Our Ref: EN010080

Date: 19 March 2019

Application by Orsted Hornsea Project Three (UK) Ltd for an Order granting Development Consent for the Proposed Hornsea Project Three Offshore Wind Farm

Examining Authority's request for further information

Figure 1: Oil & Gas Licences, Fields and Infrastructure (OGA 2018) Annotated to show Spirit Licences in Close Proximity to Hornsea Project Three

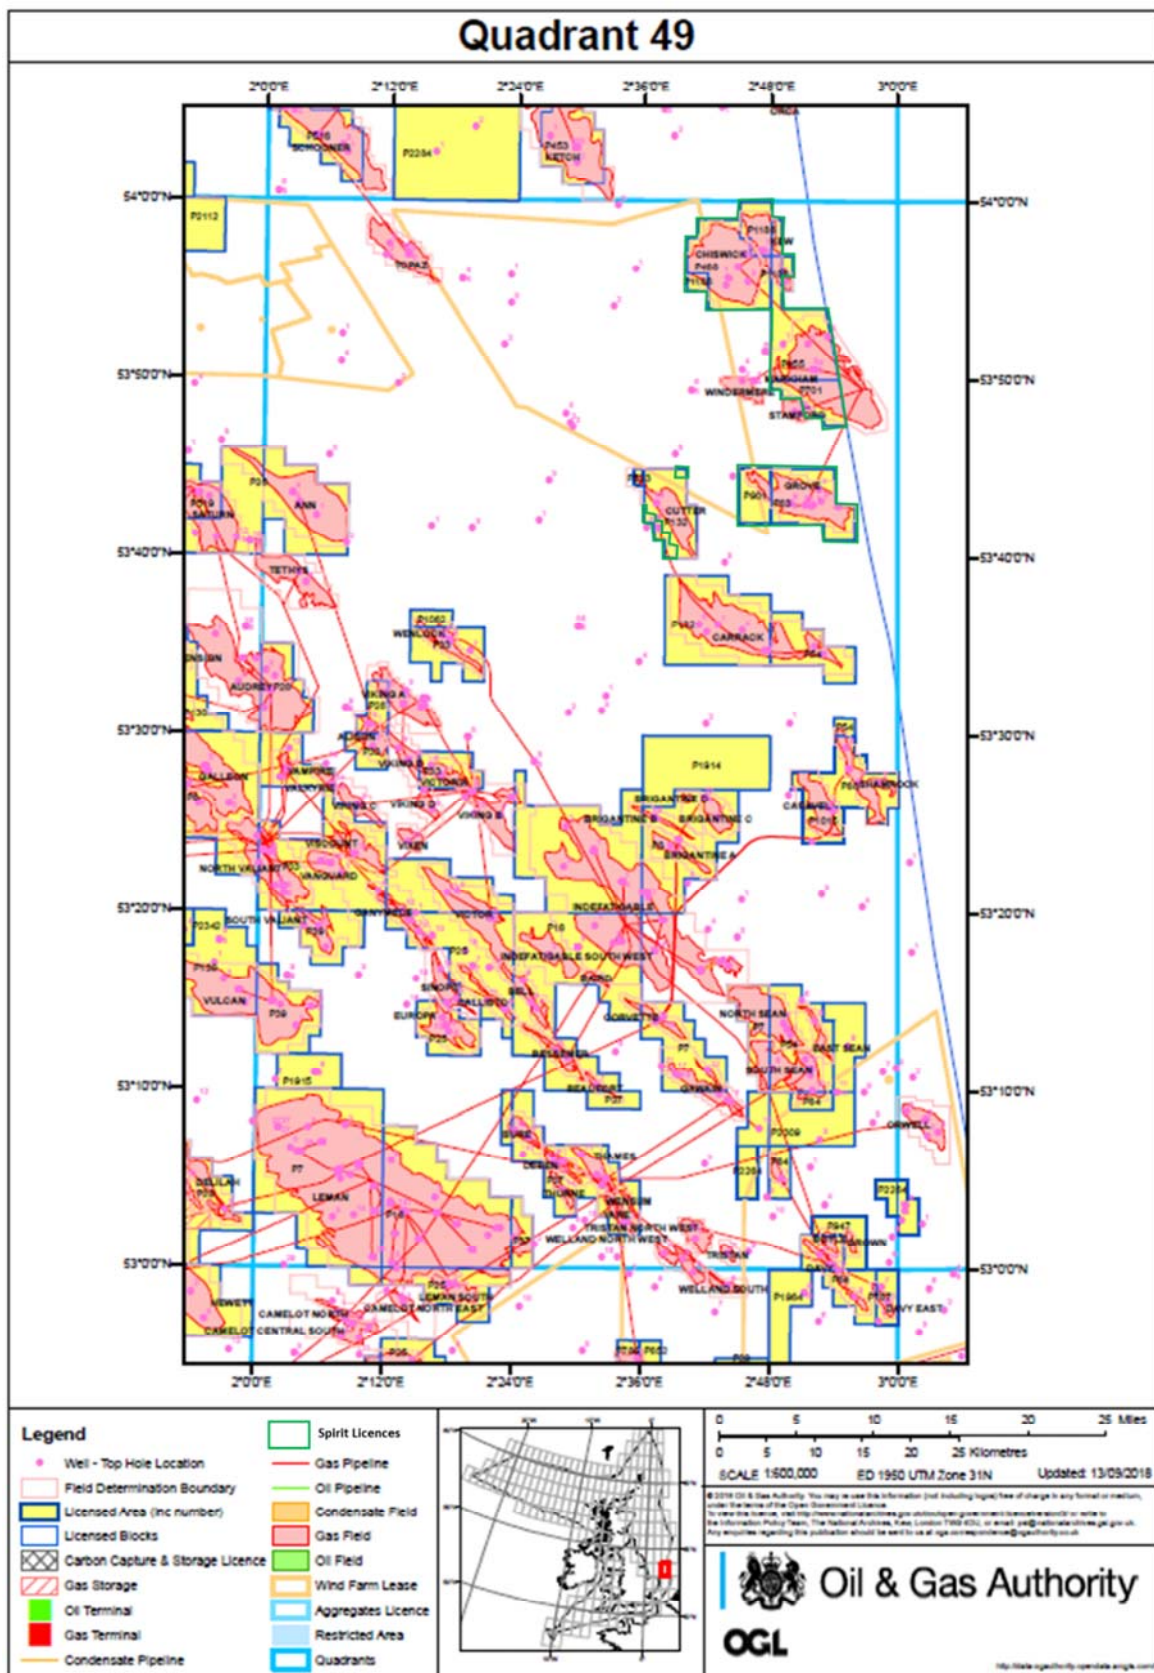
<p><i>Navigation and other offshore impacts – effects on oil and gas operations</i></p>	
F3.6	<p>Spirit Energy has proposed protective provisions which may restrict the ability to construct wind turbine generators in parts of the Order limits [REP7-093].</p> <p>Please provide plans showing the effect of the suggested provisions in relation to the proposed Order limits.</p> <p>Please comment on the likely effects on the number of wind turbine generators that could be constructed and on the generation capacity of the Proposed Development for each of the following scenarios.</p> <p>The scenarios are that the Secretary of State decides to impose:</p> <ul style="list-style-type: none"> a) The suggested obstacle-free helicopter flight volume (but not the suggested vessel exclusion area) b) The suggested vessel exclusion area (but not the suggested obstacle-free helicopter flight volume)
